Figure 3-2 Hourly Nitrogen Dioxide Levels at Monash, ACT 2006

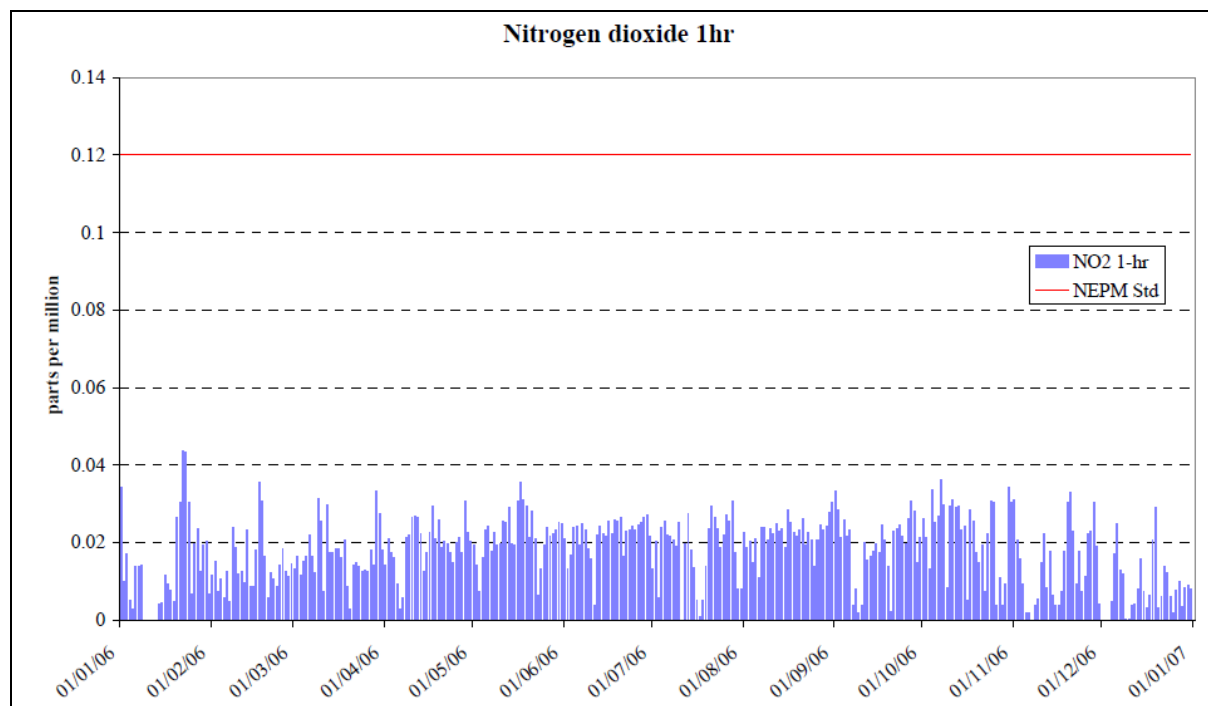
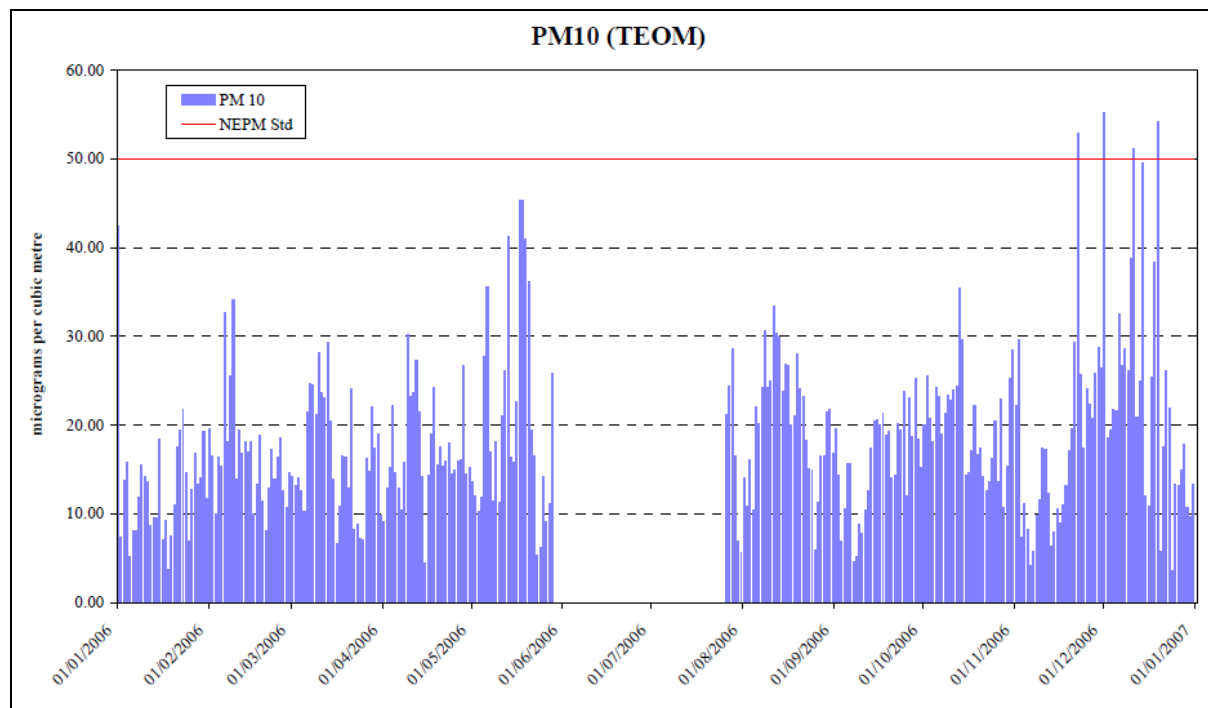
• Air Quality Assessment: This submission expresses concerns about the use of baseline data from Monash ACT being used within the assessment.

As outlined in responses to similar concerns raised and discussed in Section 3.2.2, as background to the assessment included within the EA, the assessment was refined to a level that is required by OEH, in accordance with OEH approved methodology, to demonstrate full compliance with regulatory air quality criteria. Under the assumption of continuous operation, when the highest background (i.e. the highest monitoring result from over 8,600 hourly records collected at Monash in 2006) is added to the highest estimated impact from the project, the estimated cumulative level is below the threshold at which OEH considers the air to be protective of human health and the environment.

As outlined in Section 5 of this report, AGL has committed to the preparation of an AQMP that would detail requirements for air quality monitoring during construction and operational stages of the Project.

Appendix C Noise Contours

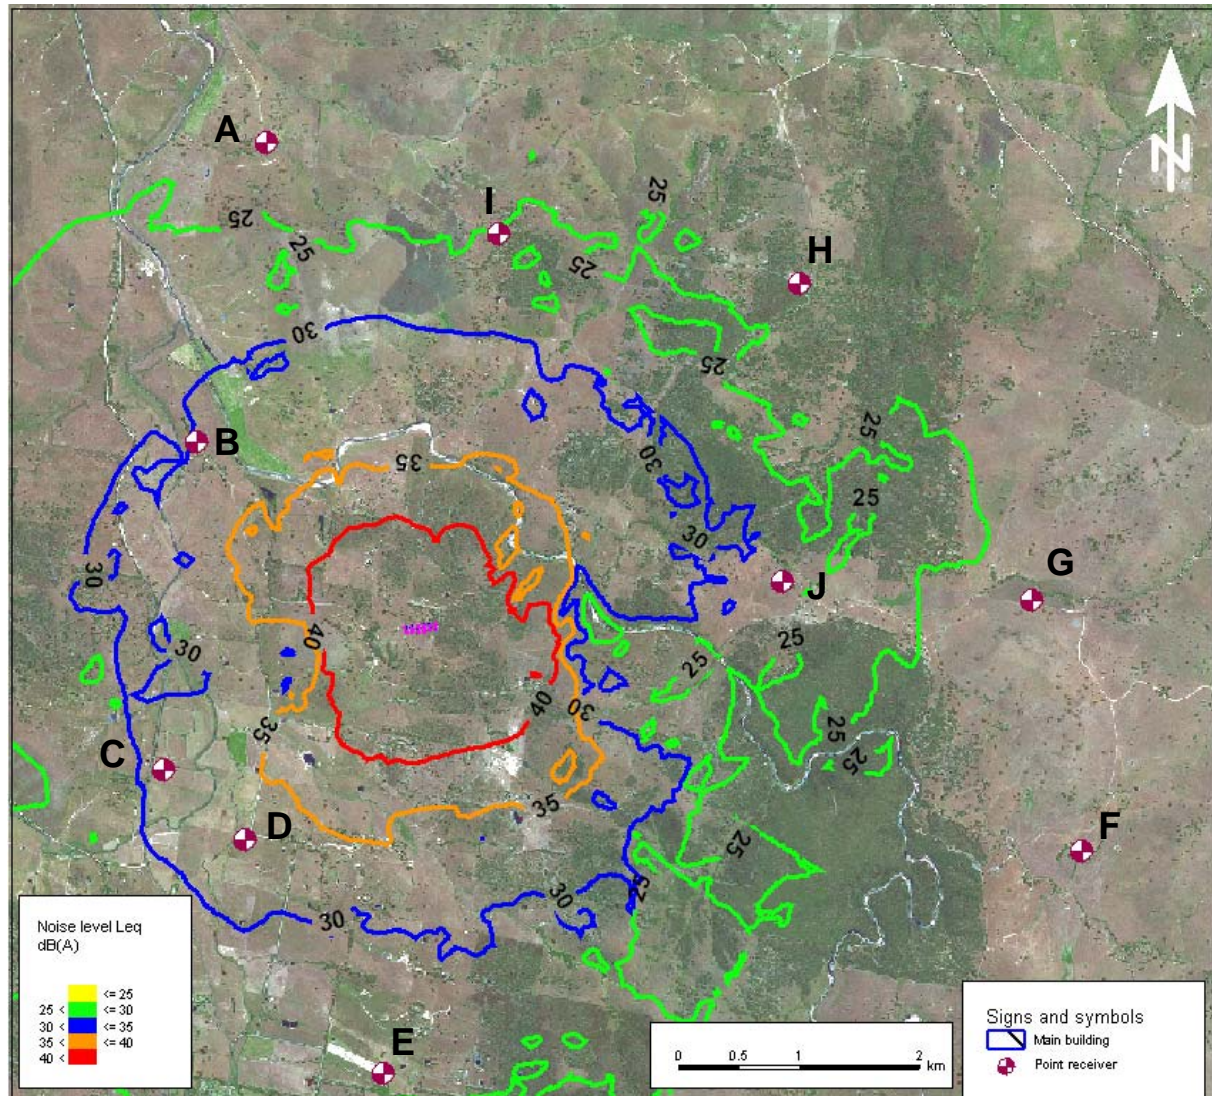
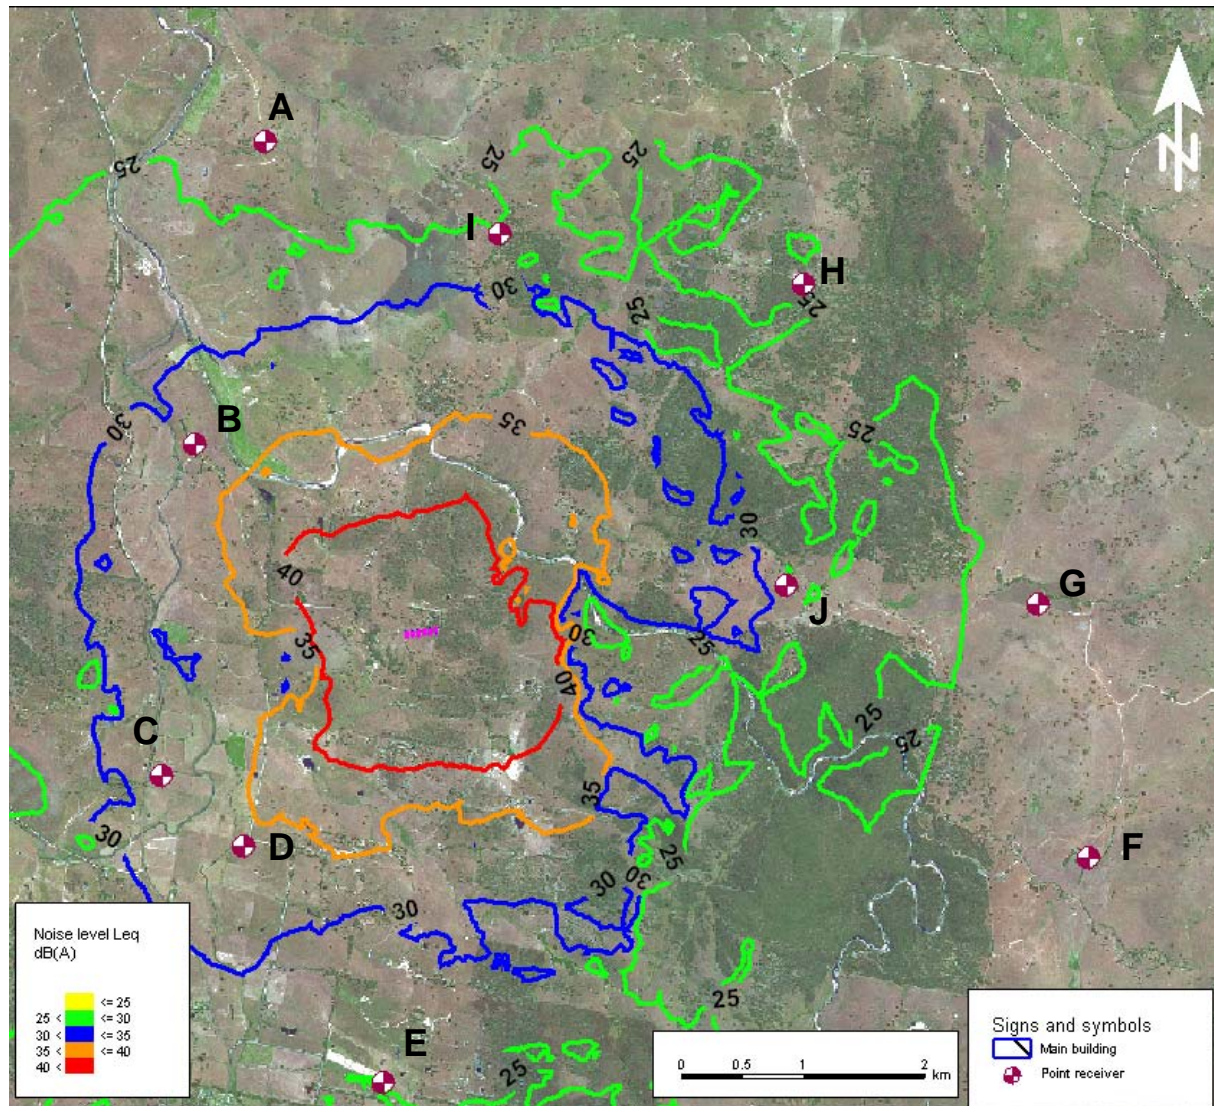
• Noise Assessment: This submission expresses numerous concerns, including a number of noise related concerns.

This submission notes the varying impacts of weather conditions such as fog on the propagation of noise in a valley. The submission also questions the accuracy of the assessment with respect to F class turbine types.

AGL notes the response addressed in relation to the issue of foggy conditions in Section 3.3.2. The noise assessment recognises that the night-time period is the most sensitive period for potential noise impacts due to the lowest background noise levels generally occurring at this time. As the Dalton power station has potential to operate at any time, the night-time noise limit criteria were adopted for the purpose of assessment.

Temperature and relative humidity parameters were set at 10°C and 75% for the *Adverse Night-time* modelling scenario, essentially as recommended by Kaliski and Duncan. Furthermore F Class atmospheric stability (moderate temperature inversion conditions) was assumed in addition to a 2 m/s windspeed with receptors downwind.

On this basis, adverse conditions, in respect to noise propagation, have been appropriately considered.

In relation to the F Class Turbine, the noise assessment considered the 109F Class turbine type, which is GE 9FA turbines, on the basis that this is the highest sound power of the turbines that were under consideration. Conservative assumptions appropriate for a worst case noise assessment were made from the information available at the start of the environmental assessment of the Project.

Figure 4-18 Detail 1 – Access Arrangements at Loop Road Corner

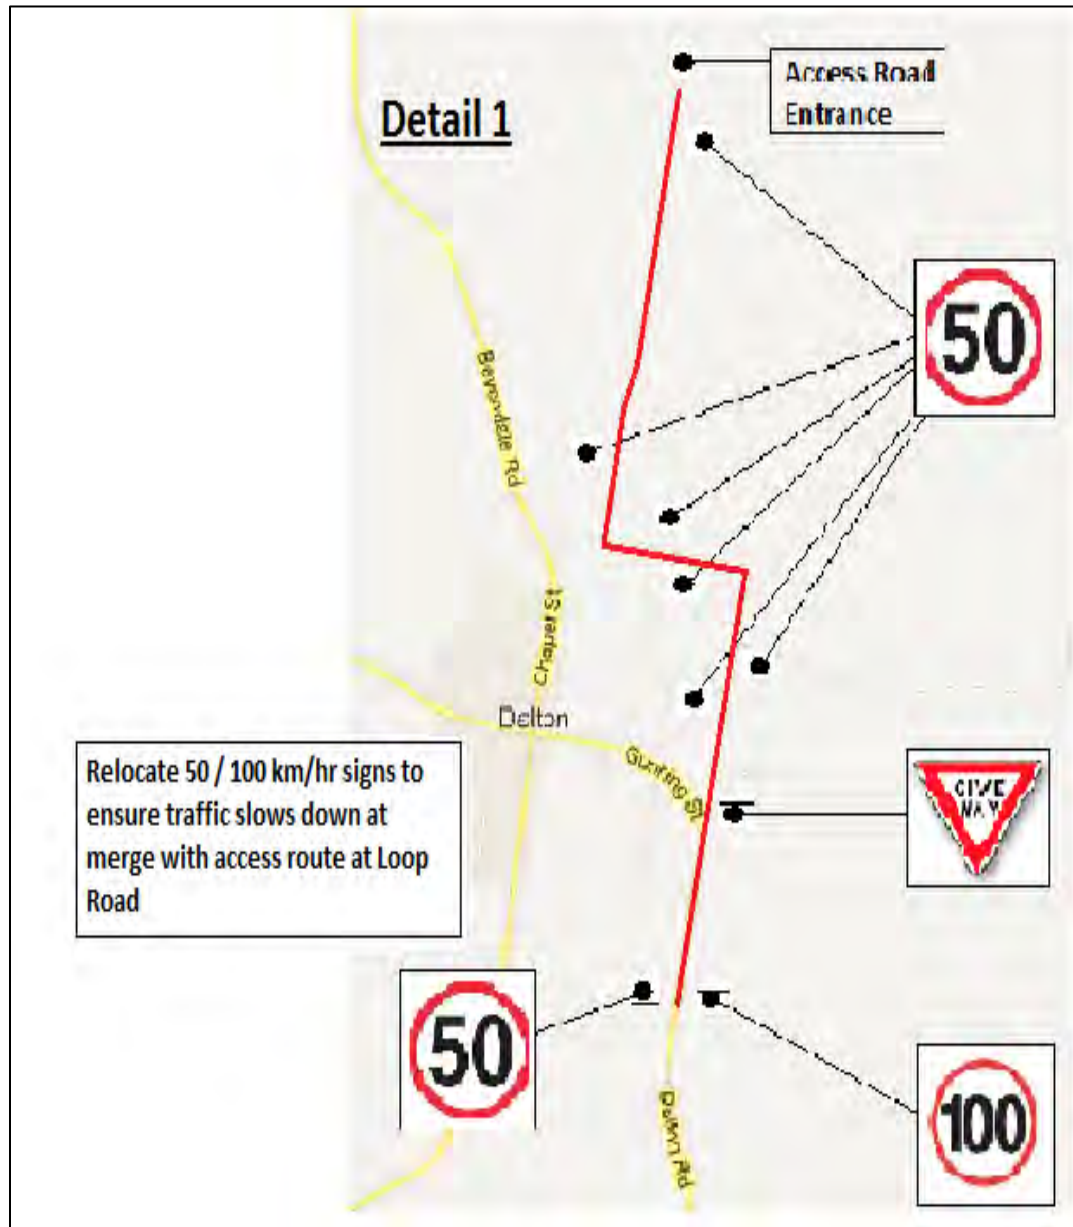
• Traffic and Transport: This submission expresses numerous concerns, including a number of traffic related safety concerns.

The submission notes concerns regarding the railway bridge, safety issues relating to commuters and school children and unsafe intersections.

AGL has responded to a number of community concerns around these issues within Sections 3.10 and 4.8 of this report. It is noted in particular that Section 4.8 notes that DP&I made the following comments on additional information required about Traffic and Transport arrangements for the proposal following their review of the draft Submissions Report:

The Draft TMP outlines a range of management measures for the Project. The plan is currently in draft form and has been provided to Council for comment, and the document has been formally tabled with ULSC.

The plan outlines various management measures to ensure that the safety and amenity of the community will be appropriately managed.

The Draft TMP outlines a range of management measures for the Project. The summary below is from the current Draft TMP being discussed between AGL and Council at present.

Location	Hazard	Control Measures
Grovenor St / WarratawSt	School children crossing roads / Increase in traffic	All efforts will be made to eliminate this hazard by planning bulk deliveries outside of periods when this area will be occupied with children / Signage to be erected as per Appendix B/ Induction and Toolbox Talks for delivery drivers / Undertake regular inspections during periods of increased traffic
Gunning Rail Bridge	Two way traffic on bridge / Pedestrian usage	Traffic lights to be established to prevent two way traffic on bridge at the same time. Lights will be sensored and set to give priority to vehicles leaving Gunning to prevent build up of traffic on Warrataw ST / Inductions and Toolbox talks for delivery drivers / Undertake regular inspections during periods of increased traffic.
Loop Road	Pedestrian usage / Children playing on Loop Road corner.	A detailed design will be provided in a further stage in order to ensure the safe ingress to Loop Rd of vehicles coming from Gunning and Dalton as well as for vehicles leaving from Loop Rd and ingressing Dalton Rd or Gunning St. Appendix D, Detail 1 proposes part of the possible calming measures to slow down vehicles.
